**Dogger Bank South Offshore
Wind Farms**

**Marine Management Organisation – Statement of
Common Ground Update**

Document Date: December 2025

Document Reference: 22.6

© ERM, 2024 Contains Ordnance Survey and ICES data. © Crown copyright and database rights 2021

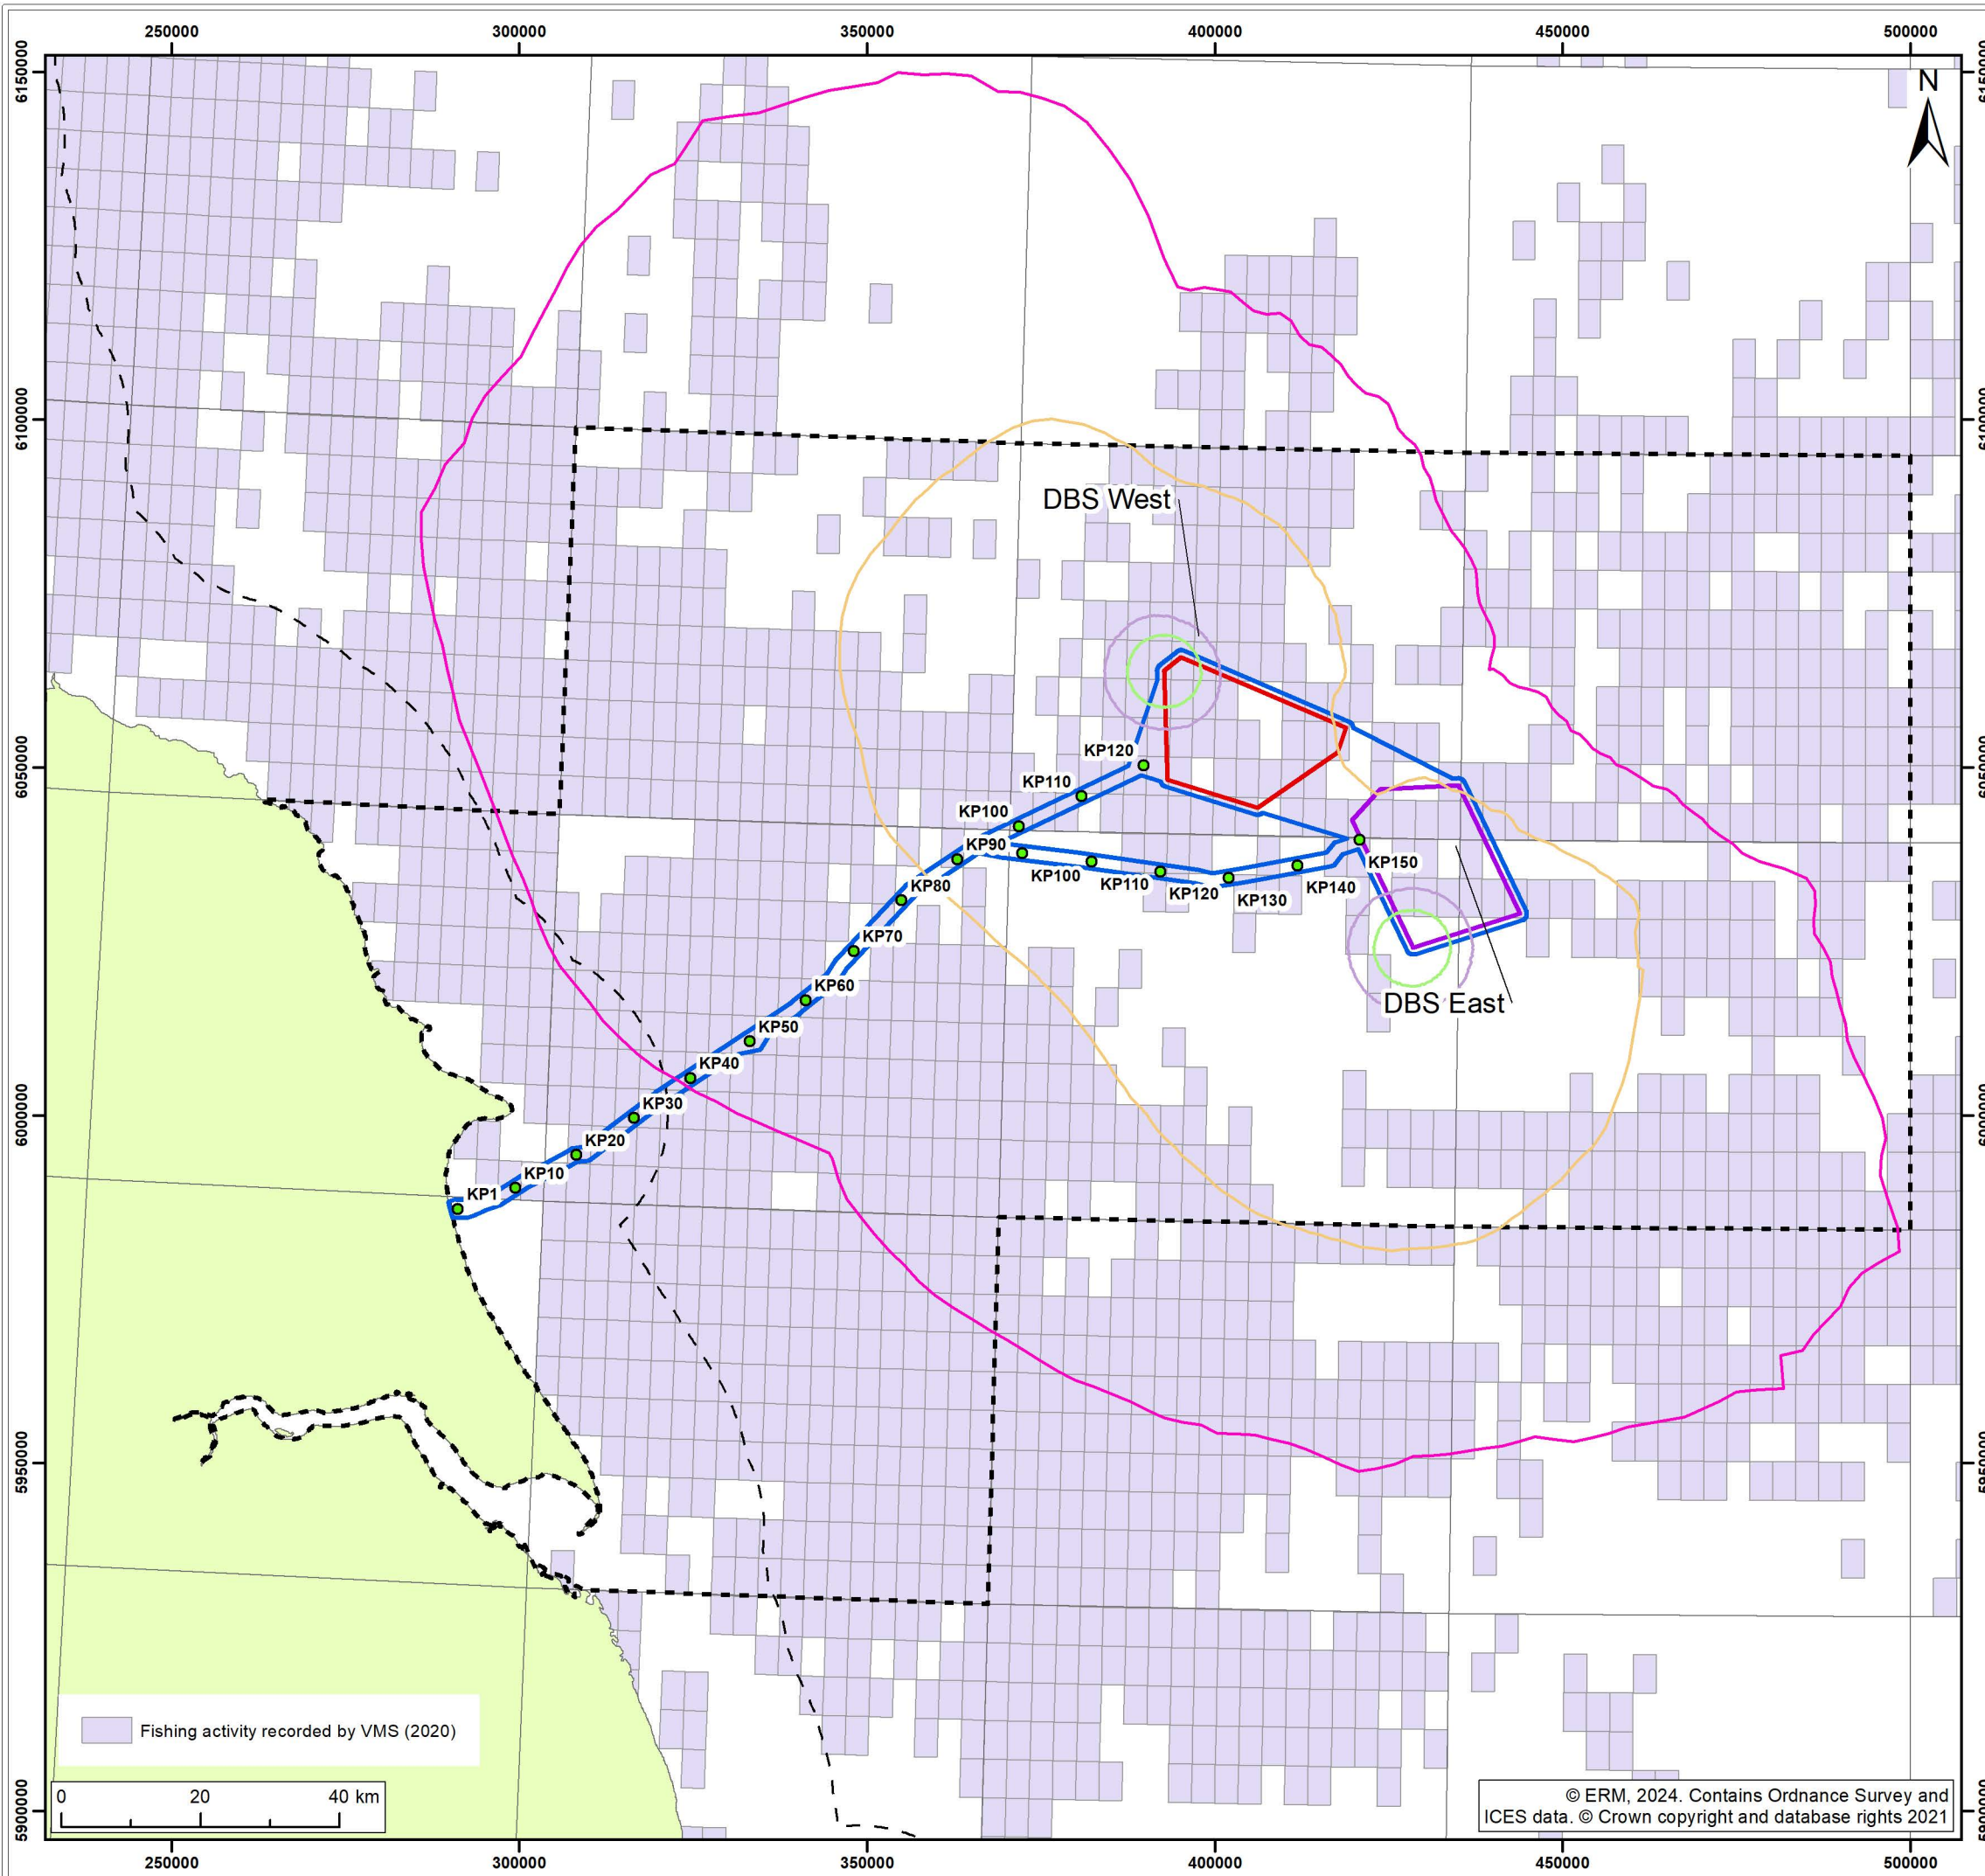
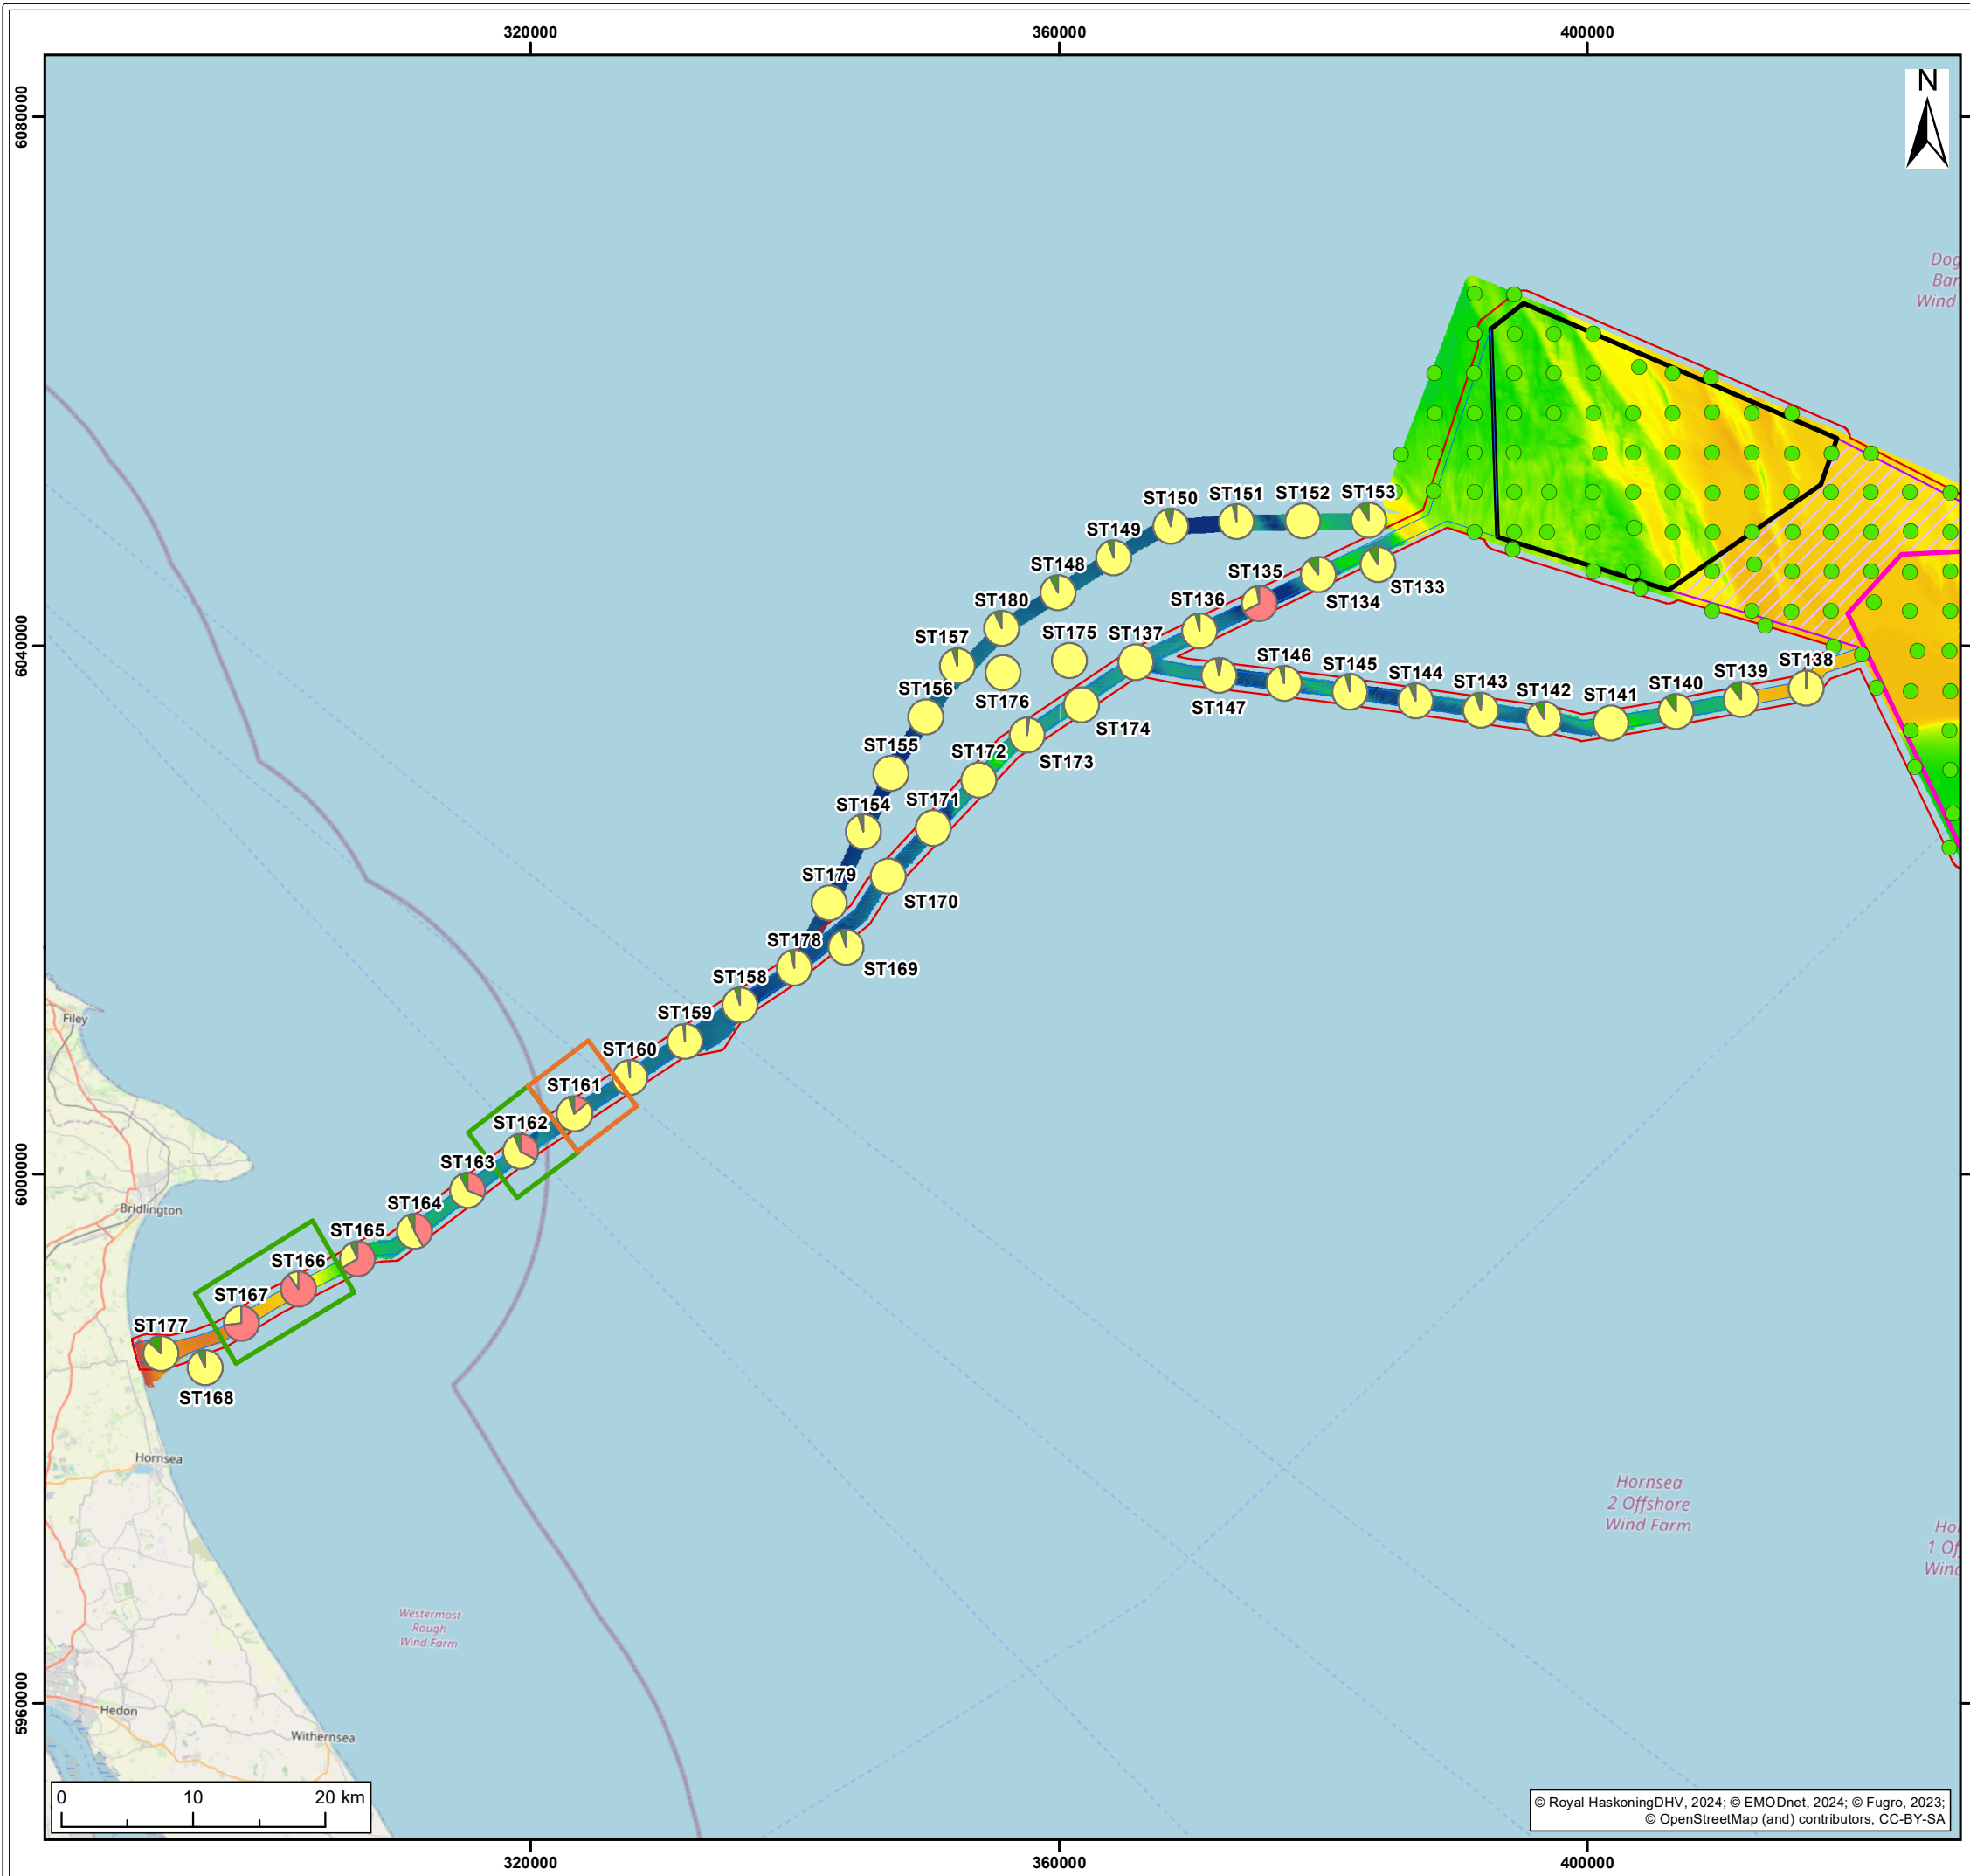
69	<p>The impact assessment methodologies used for the EIA, as presented in section 10.4.3 of Chapter 10 Fish and Shellfish Ecology [APP-091], provide an appropriate approach to assessing potential impacts of the Projects.</p>	<p>1. The MMO requests that the Applicants revises their potential herring spawning habitat and potential sandeel habitat 'heat' maps preferably using the updated version of the MarineSpace methodologies.</p>

SoCG ID	The Applicants' Position	MMO's Position	Position Status
	<ol style="list-style-type: none"> The heat mapping methodology has been updated using the latest MarineSpace guidance within the Heat Mapping Report: Atlantic Herring and Sandeel [AS-105], submitted 28th November 2024. The Applicants acknowledged the MMO's position in The Applicant's Responses to Written Representations [REP2-057] (REP1-074:2.4) but would welcome any comments at the earliest opportunity. The Applicants provided a response in The Applicants' Responses to Deadline 2 Documents [REP3-028] (REP2-061:24). In addition, figures presenting the IHLS data were provided in Appendix A (Figures 2-1 to 2-4 and Figures 3-1 to 3-4) of The Applicants' Responses to Deadline 2 Documents [REP3-028]. The Applicants acknowledge the MMO's comment. During a meeting with the MMO and Cefas on the 15th May 2025, it was confirmed that the additional figures supplied in Appendix A (Figures 2-1 to 2-4 and Figures 3-1 to 3-4) of The Applicants' Responses to Deadline 2 Documents [REP3-028] were sufficient. The Applicants consider this matter closed out. 	<ol style="list-style-type: none"> The MMO stated in the Deadline 1 submission [REP1-074] that they would provide a response to comments relating to Fisheries and Shellfish at Deadline 2 or 3. The MMO provided comments on Fish and Shellfish at Deadline 2 [REP2-061] but queried that the Applicants are missing some key data in the Heat Mapping Report Atlantic Herring and Sandeel [AS-105]. The MMO is content with the heat maps provided.
